Please ask for: Ms Iqraa Malik
Email: iqraa.malik@terraquest.co.uk
Telephone: 01212341390
Our Ref: BR/189/21/HH
Your Ref:
Date: 22nd July 2021

Application for Planning Permission for Works or Extension to a Dwelling

Development: resubmission of BR/63/21/HH
Location: 2a Merchant Street Bognor Regis PO21 1QH

Proposed Rear Extension Plans and Elevations Planning
Date February 2021
Scale 1:200 1:1250

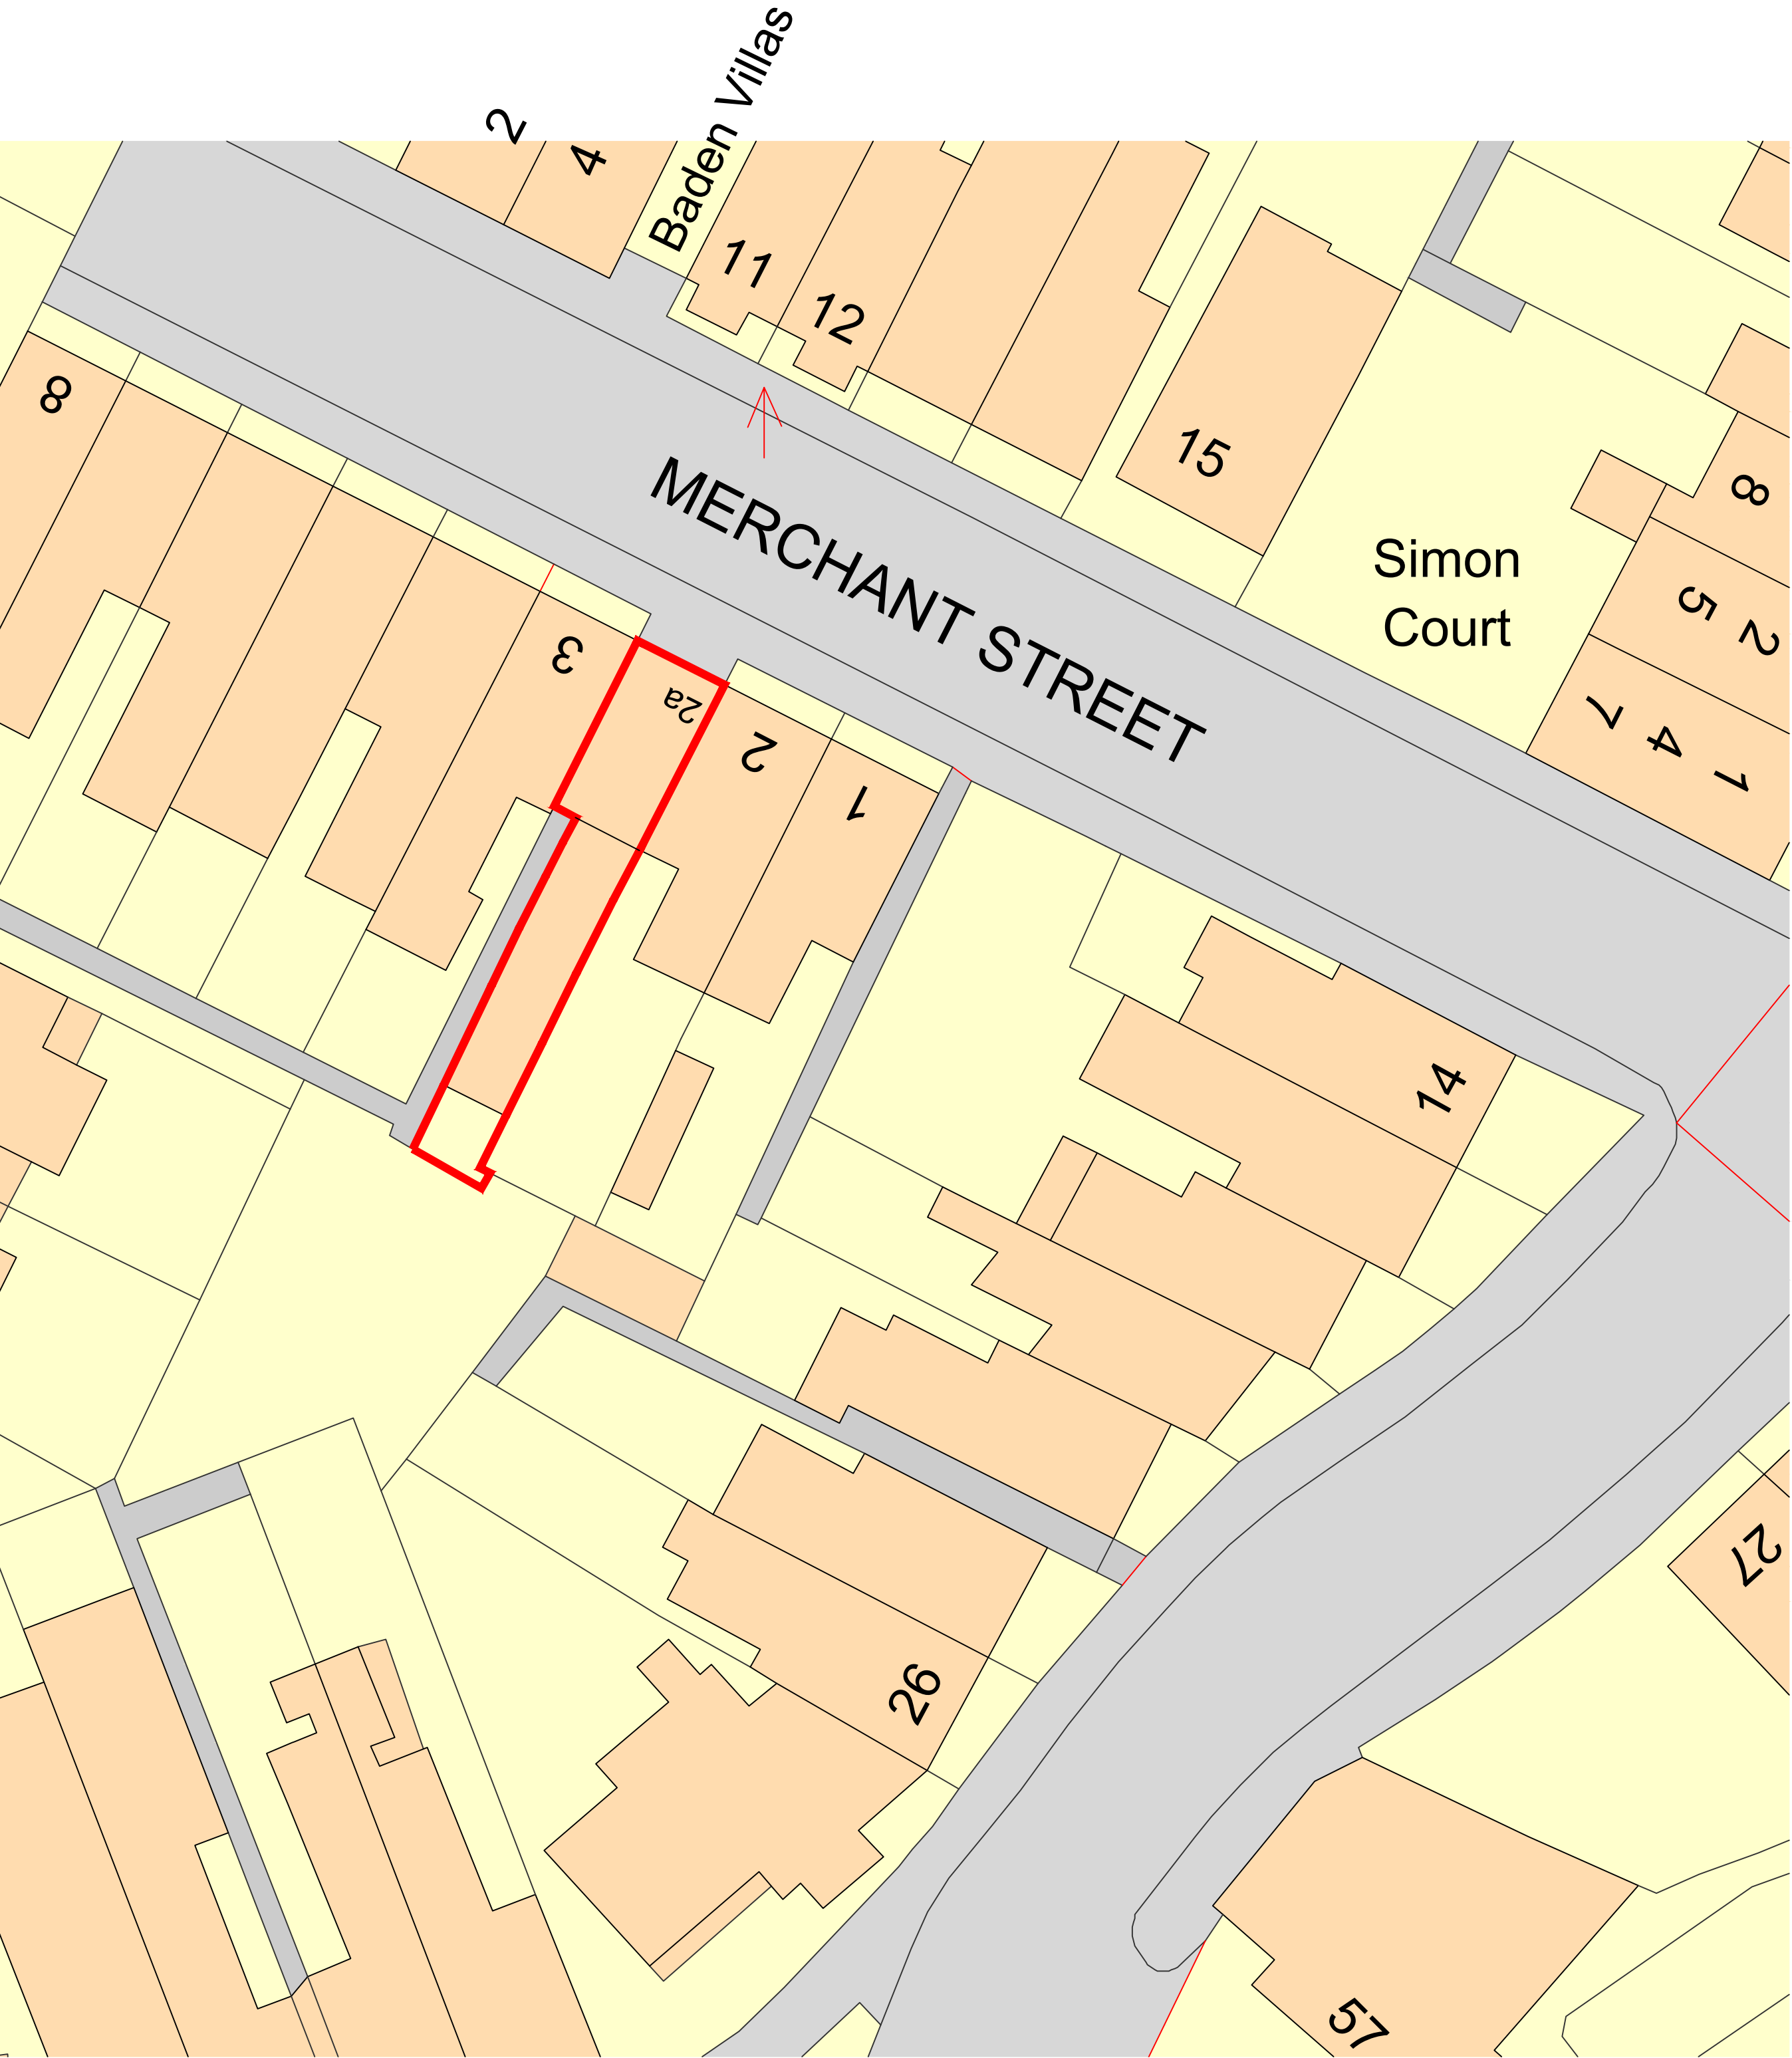
You are required to have dimensions from the proposed extension(s) to all site boundaries. Please amend.
